KITITITAS COUNTY

MEMORANDUM

TO: All Staff
FROM: Public Works Planning Review Team
DATE: May 21, 2021
SUBJECT: LPF-20-00005 Forest Ridge Final Plat Resubmittal

FOREST RIDGE - PHASE I PERFORMANCE BASED CLUSTER PLAT		
PREPARED FOR FRPP PHASE I, LLC A PORTION OF SECTION 24, TOWNSHIP 20 NORTH, RANGE 15 EAST, W.M.		
KITITAS COUNTY		WASHINGTON
DWN BY	DATE	JOB NO.
T.S.	05/2021	18069
CHKD BY	SCALE	SHEET
M.K.K./D.L.P.	1" = 500'	3 OF 7

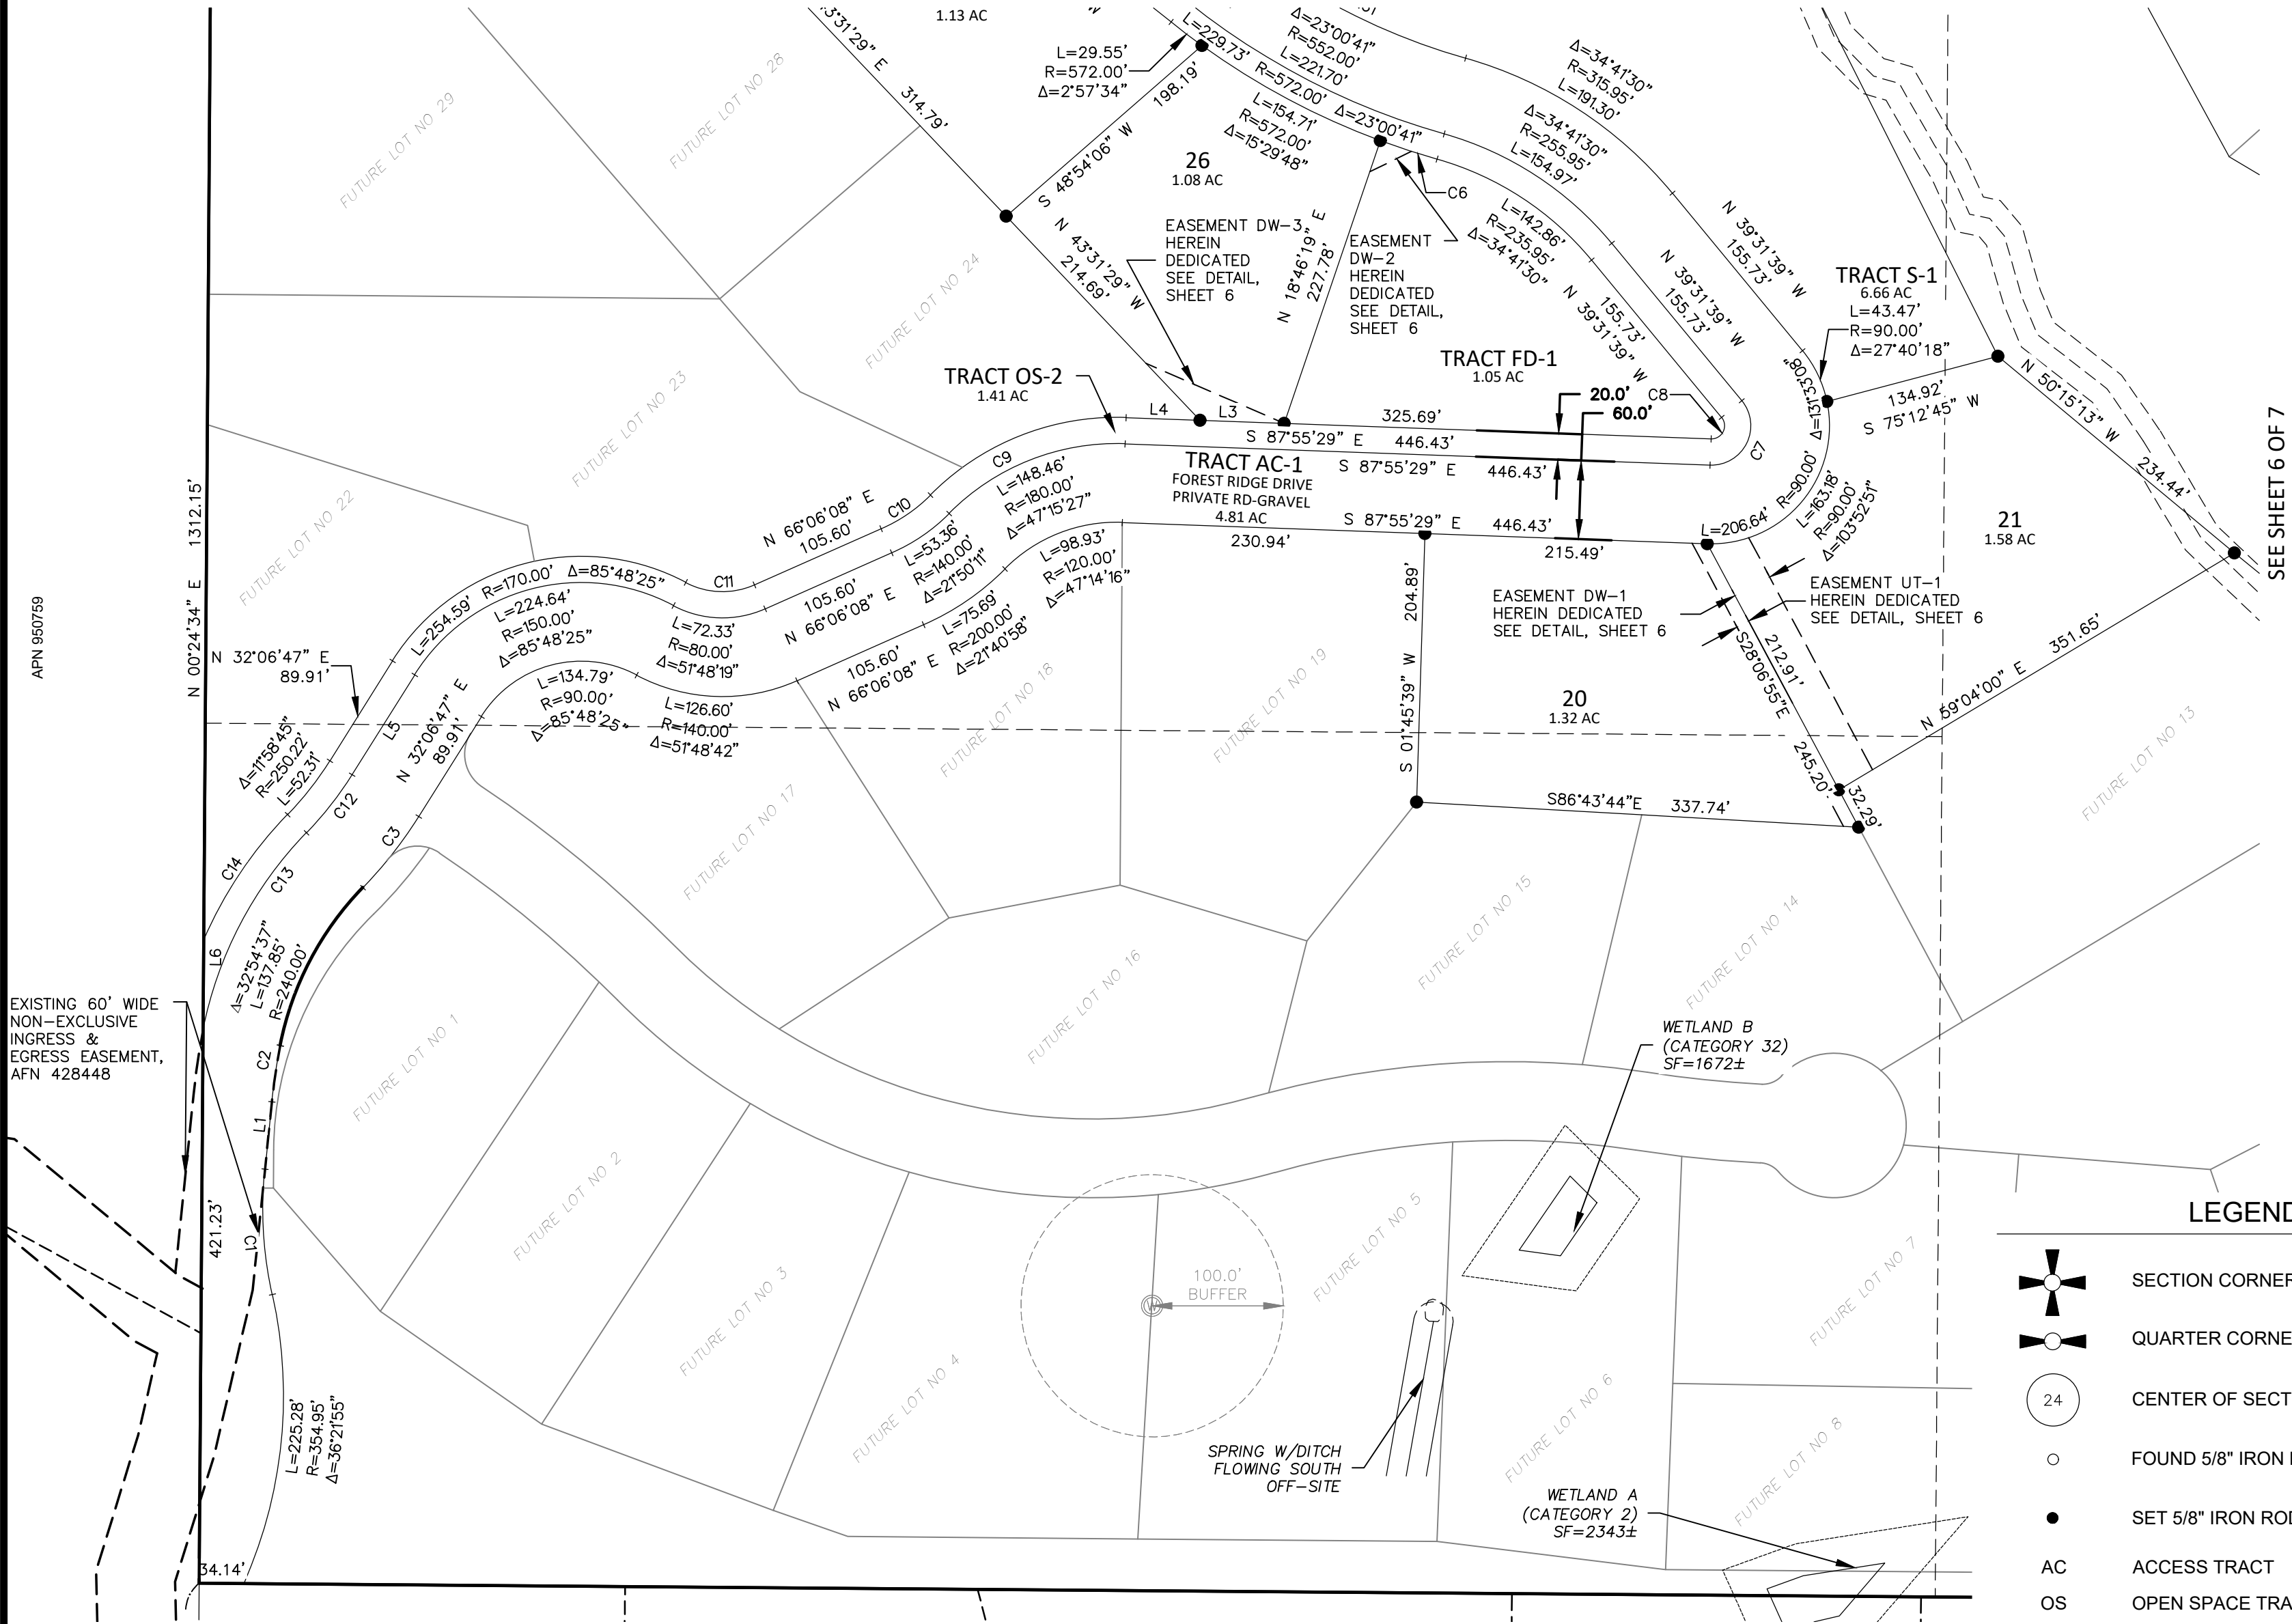
9. The N'most curve on the East line of AC-1 does not match the closure report.
10. As the Legal description identifies all the area as shown within the bold boundary on Sheet 3, the remainder area should be identified as a Lot or Tract, and area shown.

FOREST RIDGE - PHASE I PERFORMANCE BASED CLUSTER PLAT PREPARED FOR FRPP PHASE I, LLC A PORTION OF SECTION 24, TOWNSHIP 20 NORTH, RANGE 15 EAST, W.M. KITITAS COUNTY WASHINGTON		
DWN BY T.S.	DATE 05/2021	JOB NO. 18069
CHKD BY M.K.K./D.L.P.	SCALE 1" = 100'	SHEET 4 OF 7

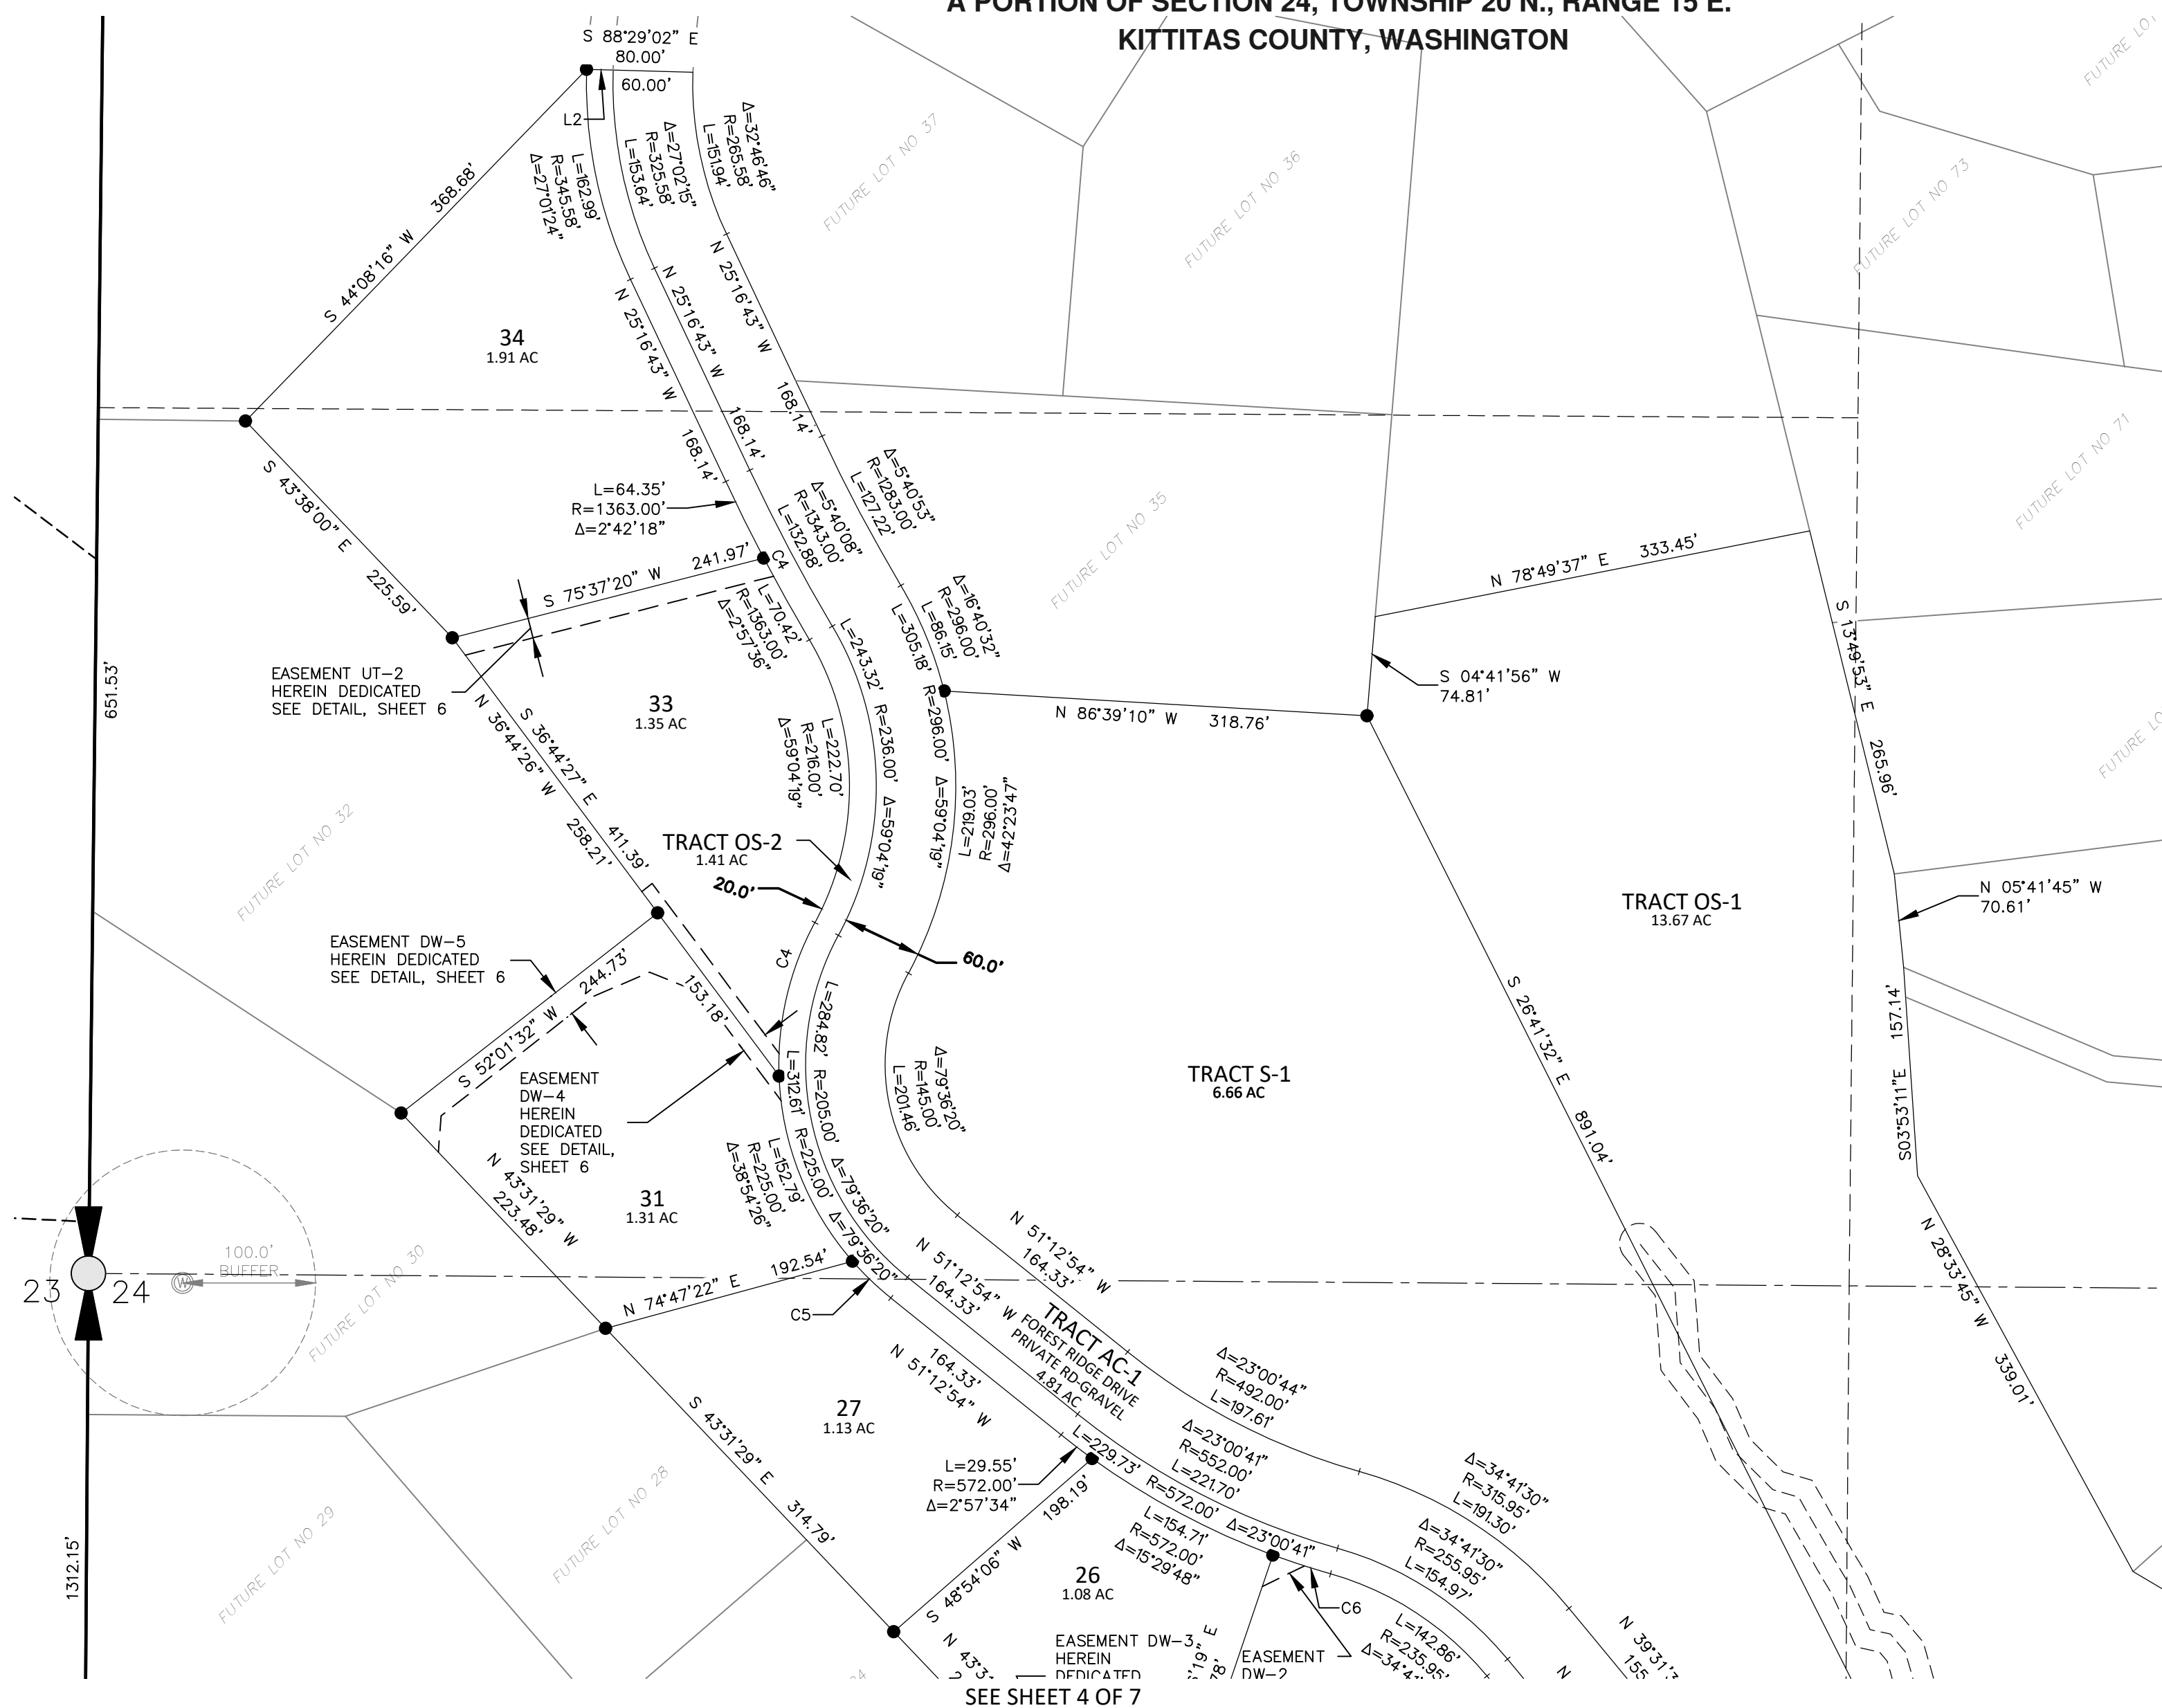
7. Sheet 4 and 5 of 7 references Easement detail sheet 6, for example reference on Tract FD-1. Reference should be to detail sheet 7.
8. Tract AC-1 is identified as Forest Ridge Drive, a private gravel road. KCC 12.12.010 requires a Private Road Maintenance Agreement. If this will be under a home owners association, please include the following note on the face of the plat: *Private Road Tracts, Drainage Pond tracts, Service Tracts, Access Road Tracts, and Open Space tracts are hereby granted and conveyed to the homeowners association upon recording of this plat. Except as otherwise noted, hereon, said Homeowners association is hereby responsible for all maintenance and management obligations associated with said tracts. Should the homeowners association fail to properly maintain said tracts, the owners of all lots of this plat shall be equally responsible for maintenance of said tracts.*

2. All the easements DW-1 through DW-5 and UT-1 through UT-2 incorrectly reference sheet 6 rather than Sheet 7.
3. The dimension of 421.23 at the south end of AC-1 should show 'crows feet' to identify what the dimension is measuring.
4. There are still multiple occurrences of crossing linework obscuring text.
